Submissions Report No. 2  
New High School in Bungendore  
SSD-14394209

On behalf of  
NSW Department of Education  
November 2022

This Submissions Report has been prepared by Mecone Group Pty Limited on behalf of the NSW Department of Education to support the proposed new high school in Bungendore (SSD-14394209).

Designed	Reviewed	Drawn	Sheet
MW	SCM	MW	B1
Job No.	Status	Date	Scale
5555	SSDA	OCT '21	1:200
Drawing No.	BHS-CE-2031	Revision	L

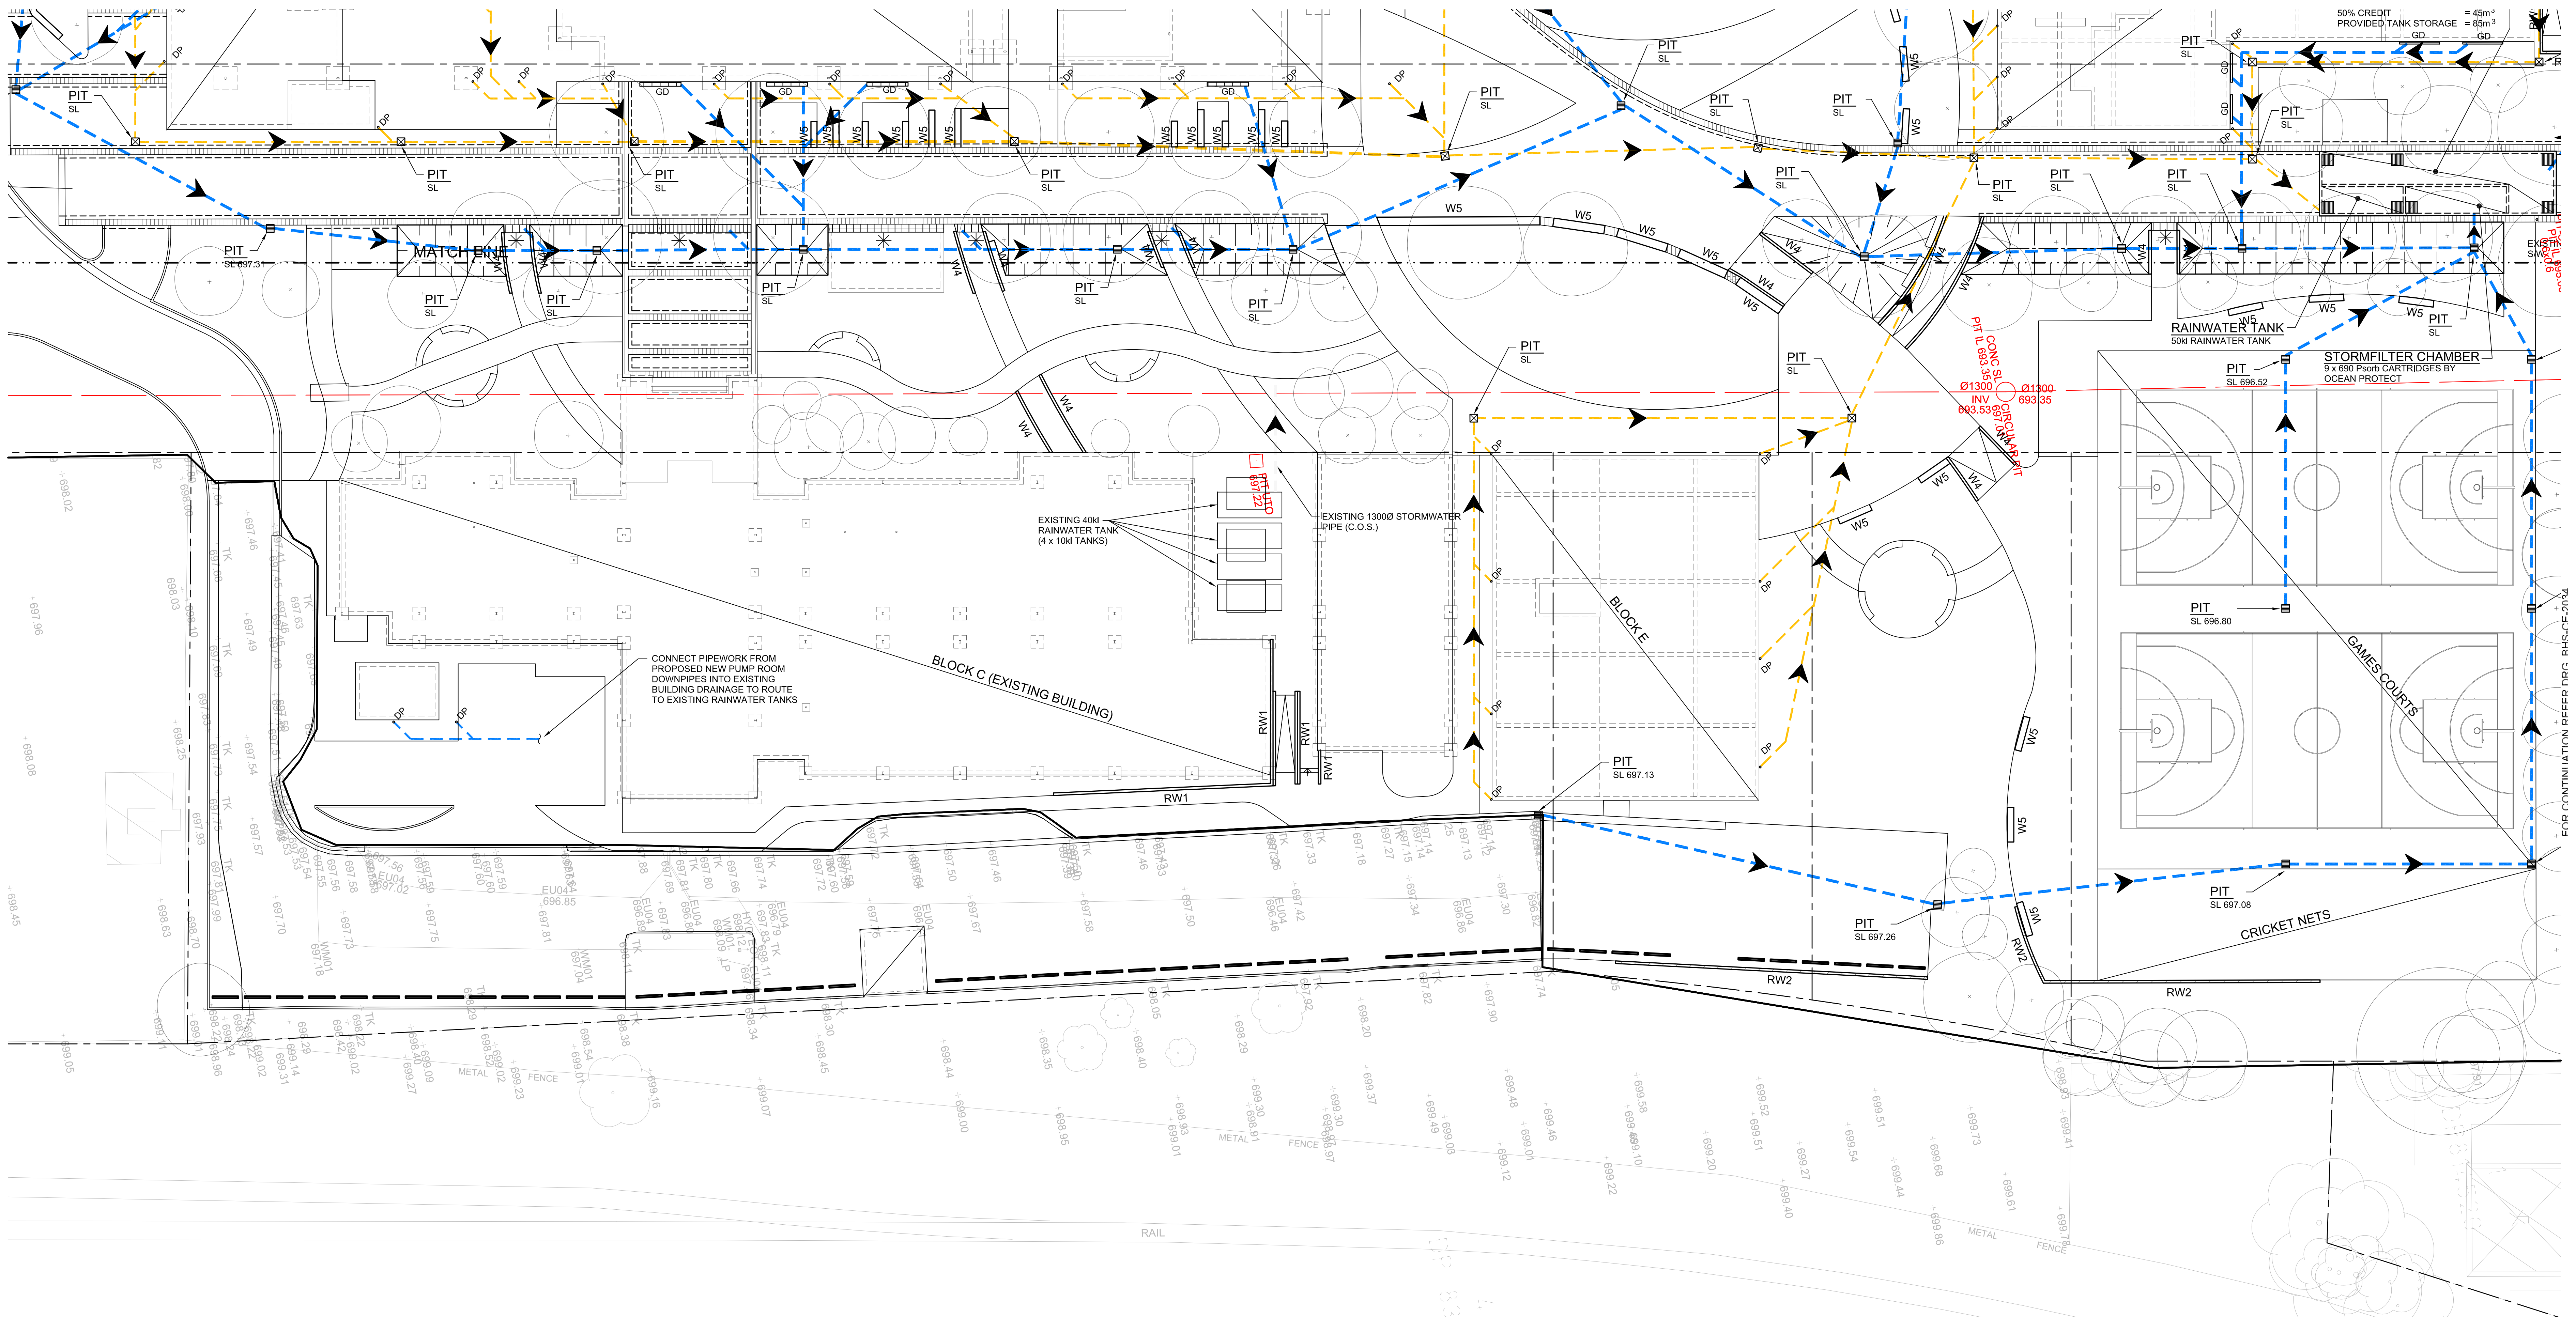
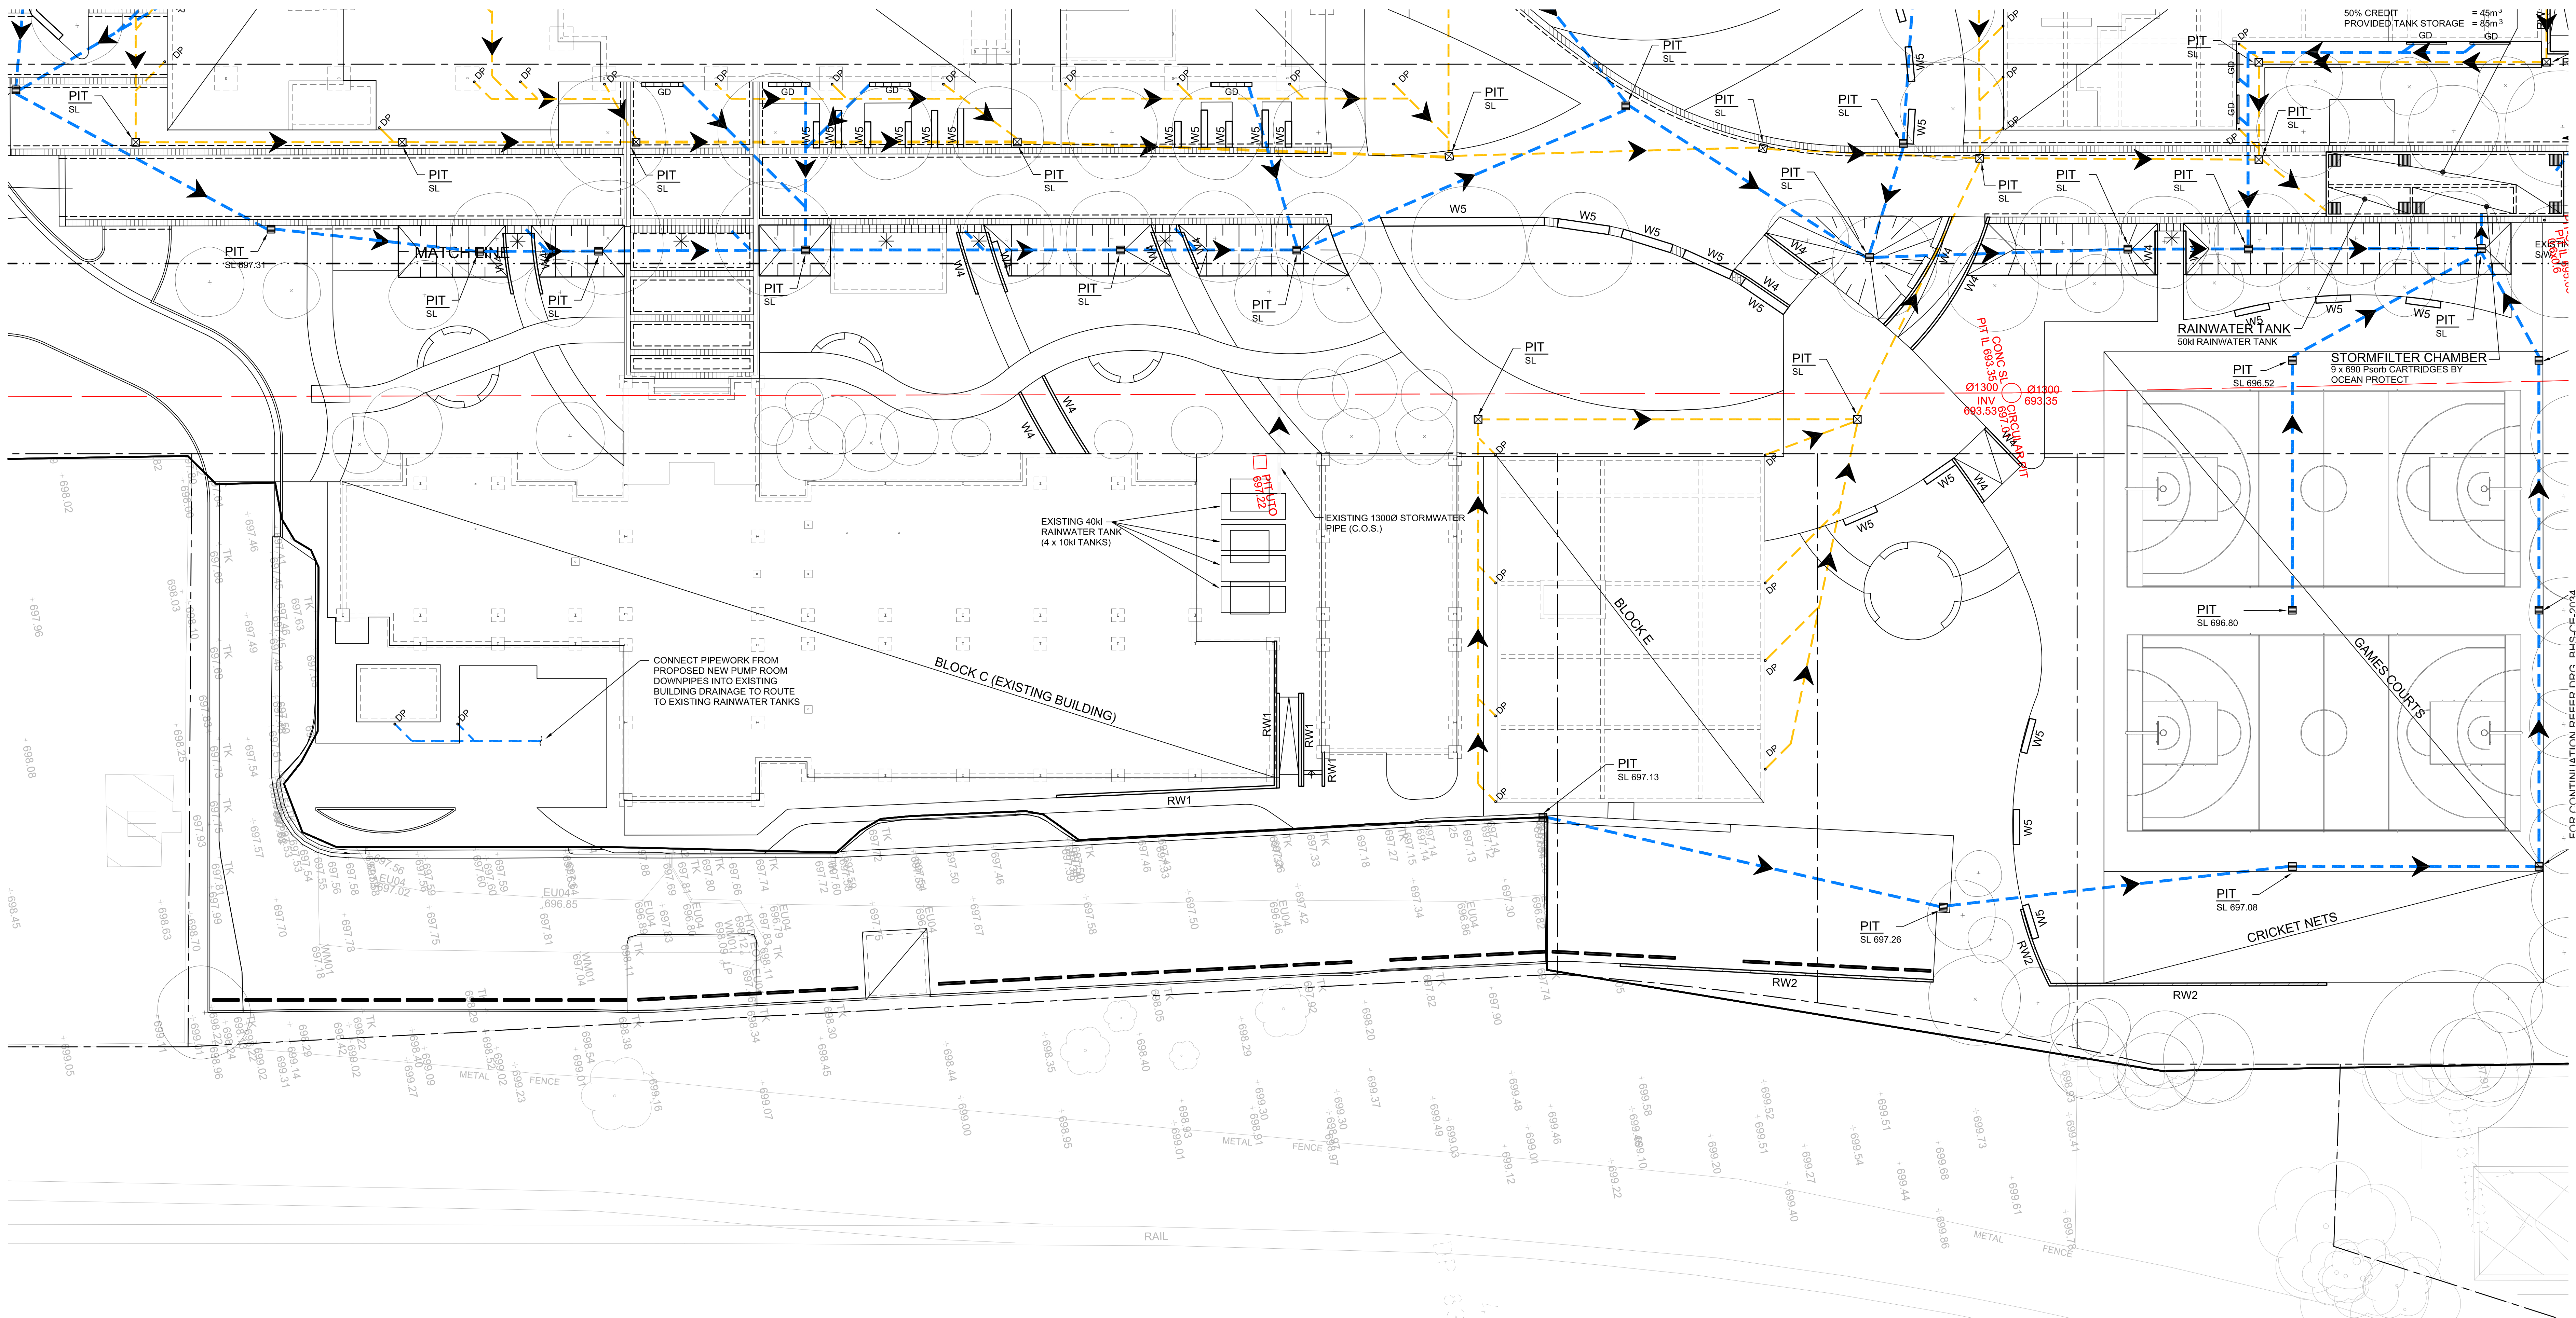
Provide plan BHS-CE-2053 which shows on-site detention details as referenced in Plan BHSCE-2031 and the Amendment Report, but not provided on the civil drawings.	Plan BHS-CE-2053 is provided in the updated civil drawings at <b>Appendix 5</b> .
